At this stage we **would not recommend discharge of conditions** until the following comments are addressed.

Condition 9 –

Below Ground Drainage Layout

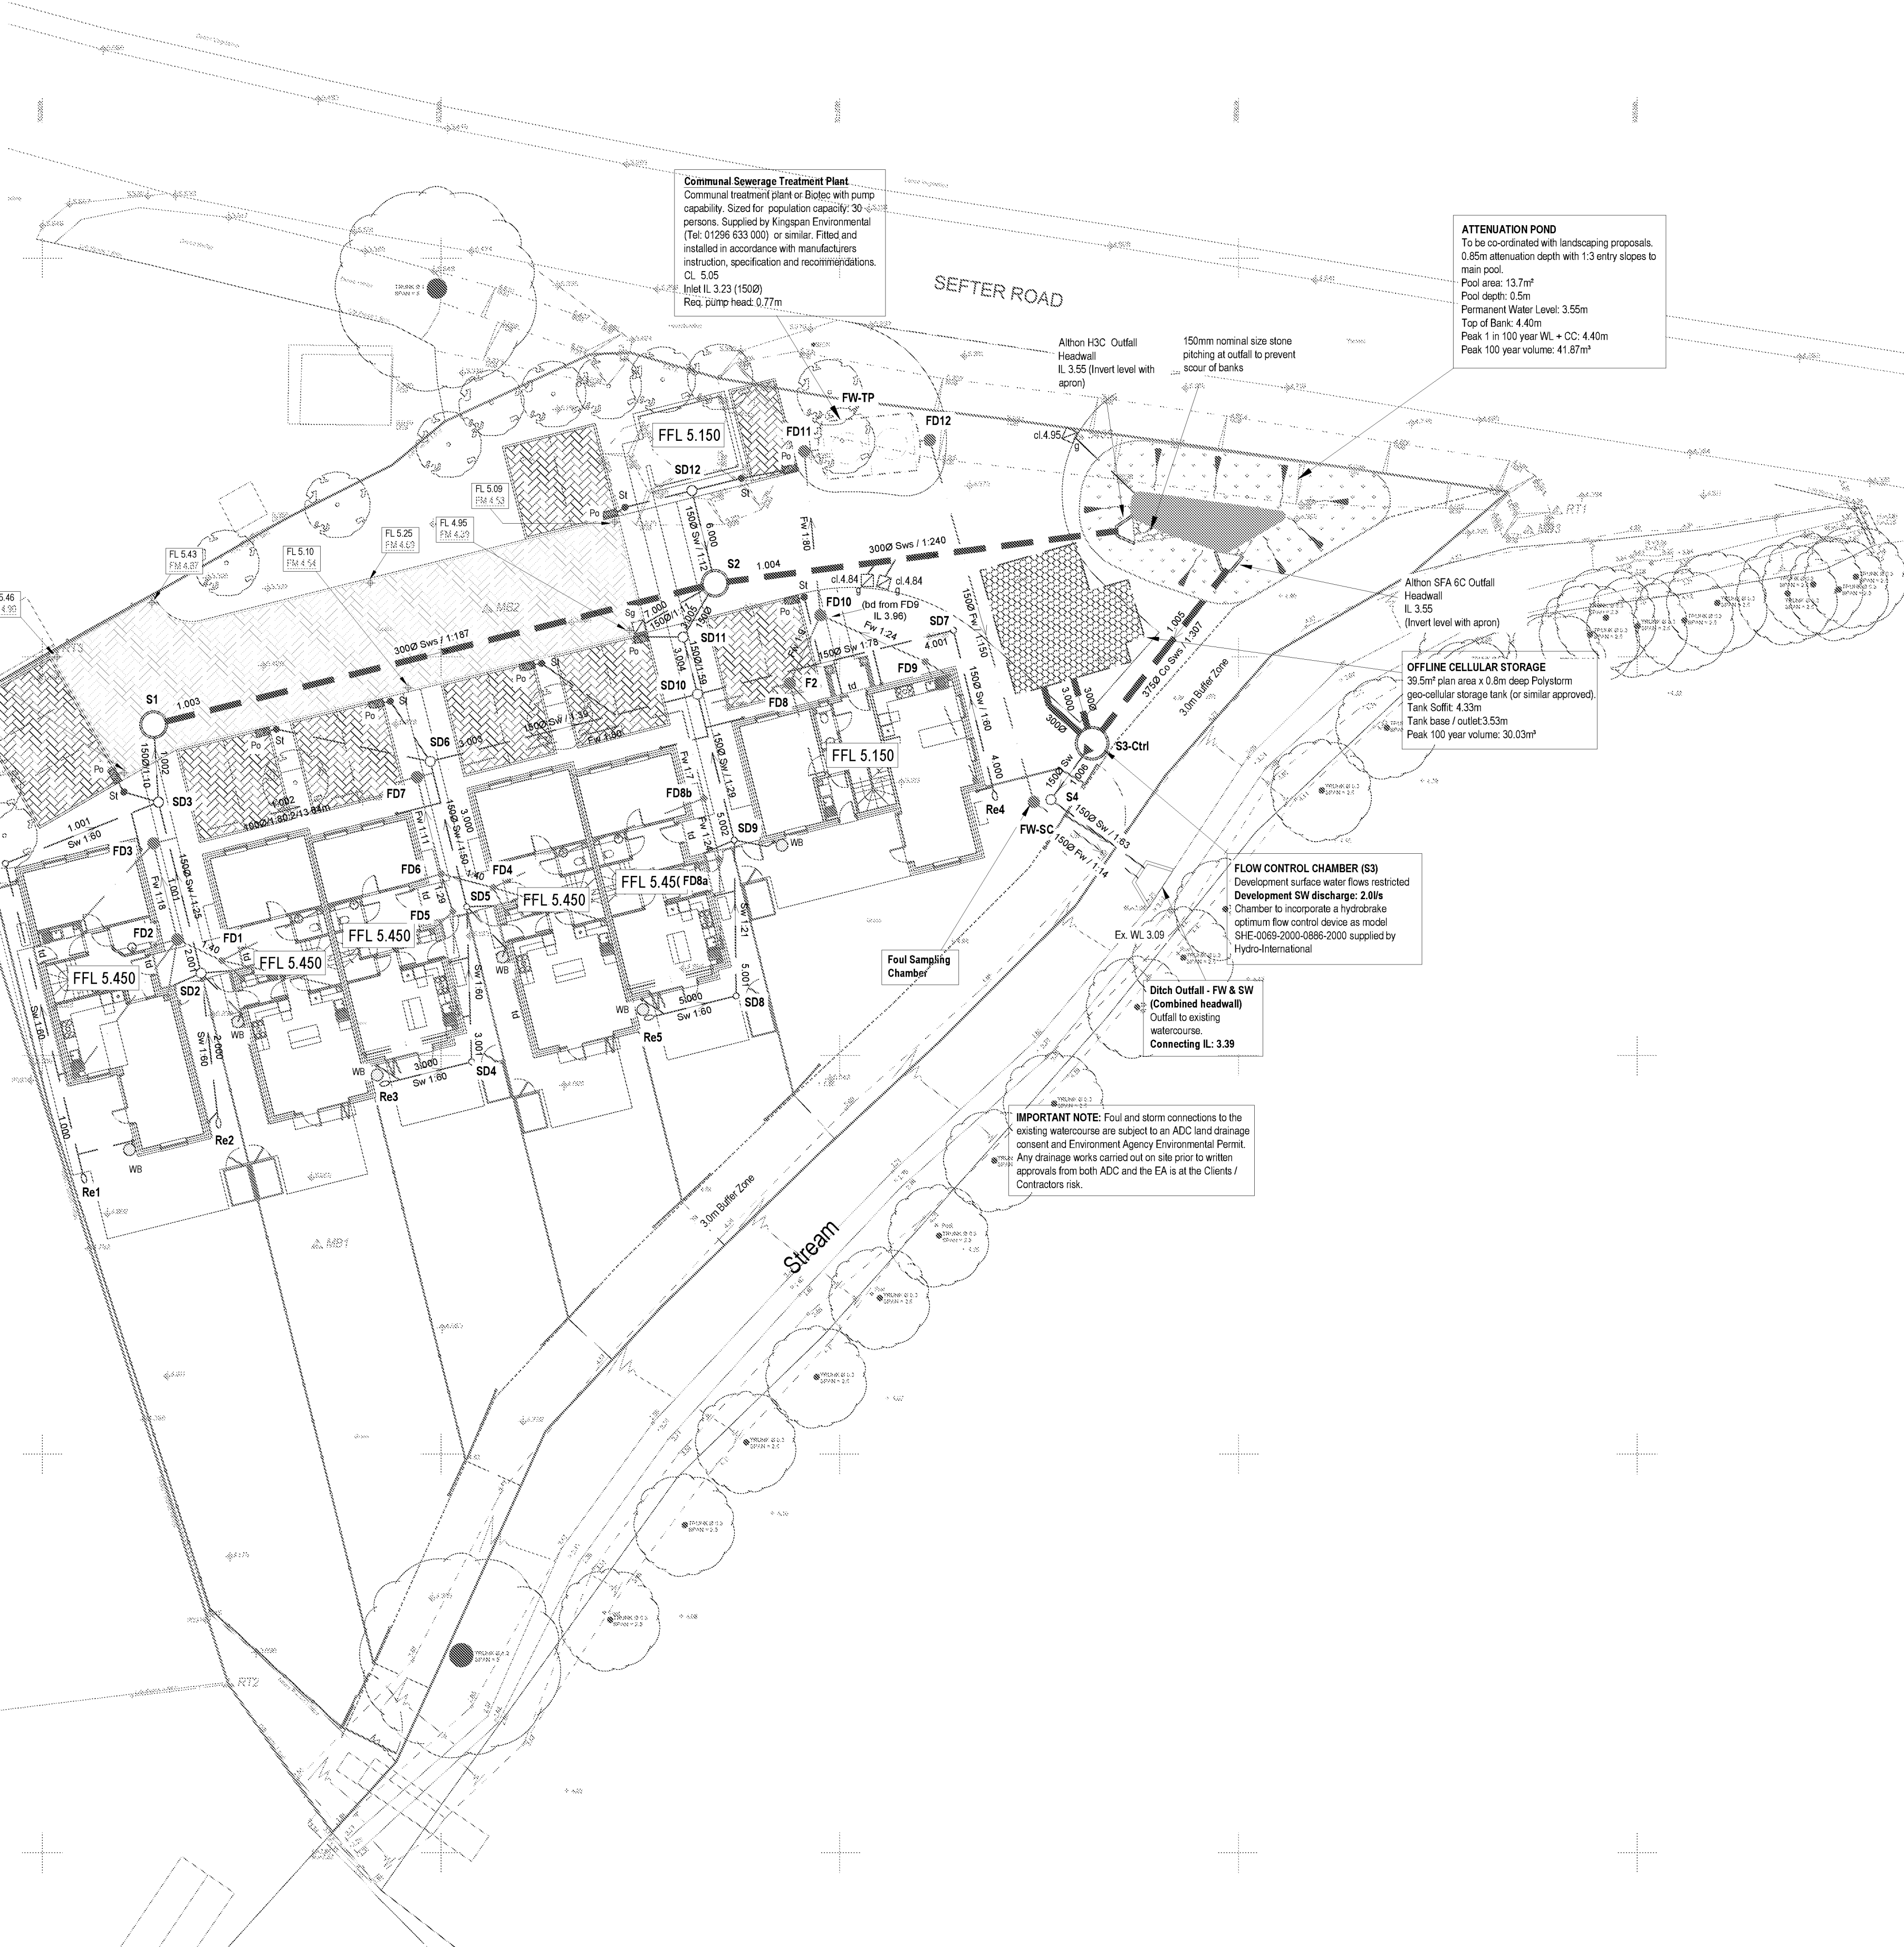
- 2) The design of the pond / basin should include a freeboard of at least 150mm, preferably 300mm or more (in accordance with C753).
- 3) Regarding the geo-cellular storage, there is a note on both the drainage layout plan and section detail of the storage tank which states "Polypipe Civils (or similar approved)". At DOC stage we require certainty that specifications will be followed, as any changes to the specification may impact associated calculations. As there is no mechanism for enforcing further review of such changes, which could result in significant changes to the design if different crates are approved, please can the applicant remove the "or similar approved" section of this comment from the drawings.

- In the absence of a suitable analysis of expected surcharging depths within the adjacent watercourse, please model a reasonable worst case surcharged outfall, with a fixed surcharged water level set equal to the top of bank level at the outlet (as previously requested).
- 8) The type of membrane surrounding the permeable paving sub-base / specification should be specified on the drawings.
- 9) The pond has a note which states; "To be co-ordinated with landscaping proposals." This should confirm that the only details that still need co-ordinating are the planting scheme, as other details leave the pond open to partial redesign, e.g. if landscaping takes precedence over drainage - shallower side slopes or smaller forbay.
- 10) All inlets into the pond must have headwalls. The inlet pipe from gully to the north west of the pond needs an outfall headwall on the drainage layout plan.

Typical Section Through Light Duty Permeable Block Paving Showing

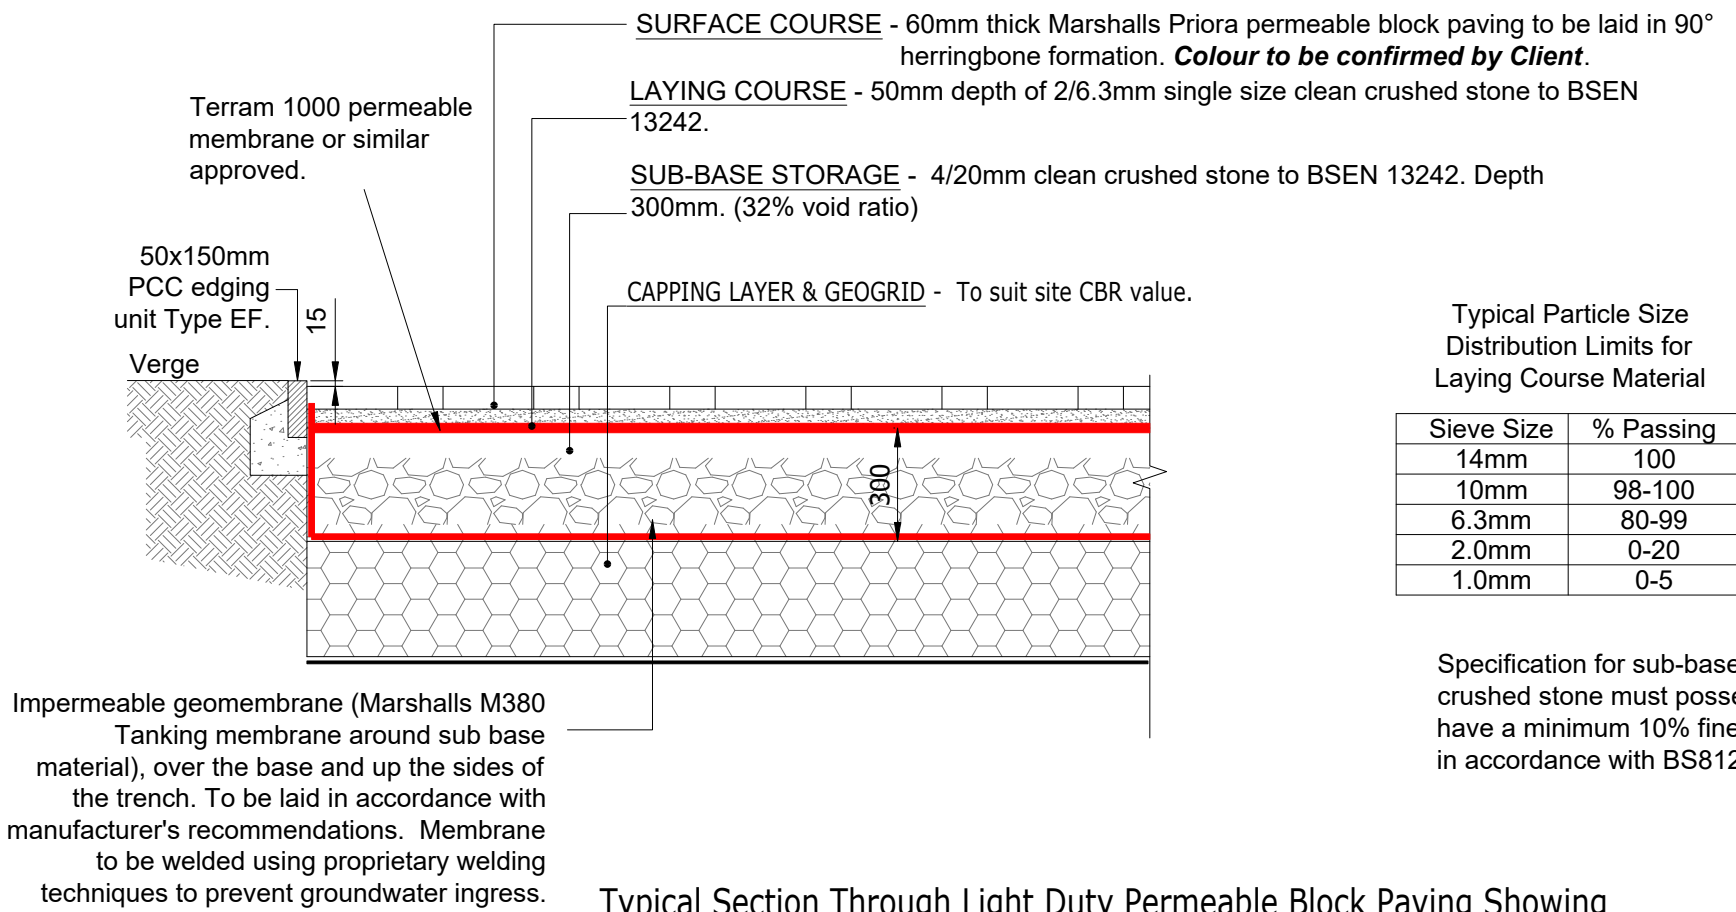
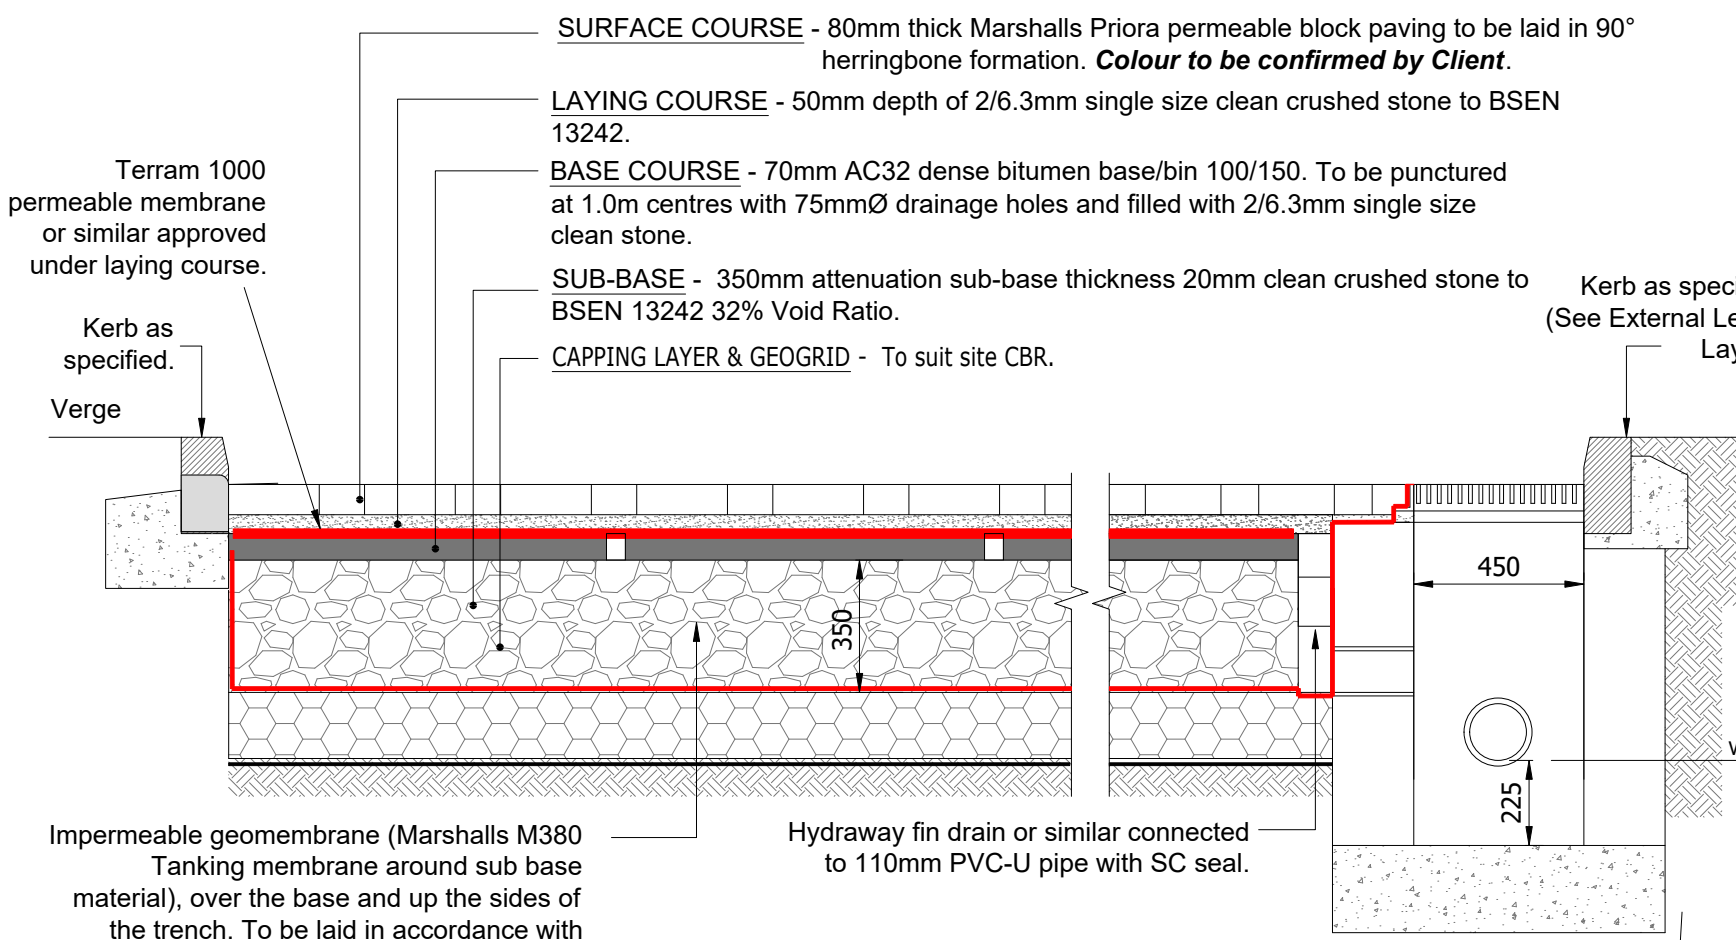
- 1) A 1:80 gradient has been applied to the permeable paving sub-base within the drainage calculations. Nonetheless, the slope across the paving appears to be steeper than this value. The applicant should provide justification for why a 1:80 gradient has been selected within the calculations, to ensure that any differences between the calculations and design levels will not impact on the hydraulic performance of the permeable paving system.

Commented [SH1]: Looks like gradient on the permeable sub-base is about 1:40 not 1:80 used in the calcs – this needs double checking from a scaled plan. Cant be right as when taking values from calcs 1:60 is the shallowest possible solution.
I think they have good reason for this as the gradient does shallow to virtually 0 in the lowest part of the site - but they havnt confirmed why or that it will work so we must work under the assumption that it hasn't been considered.
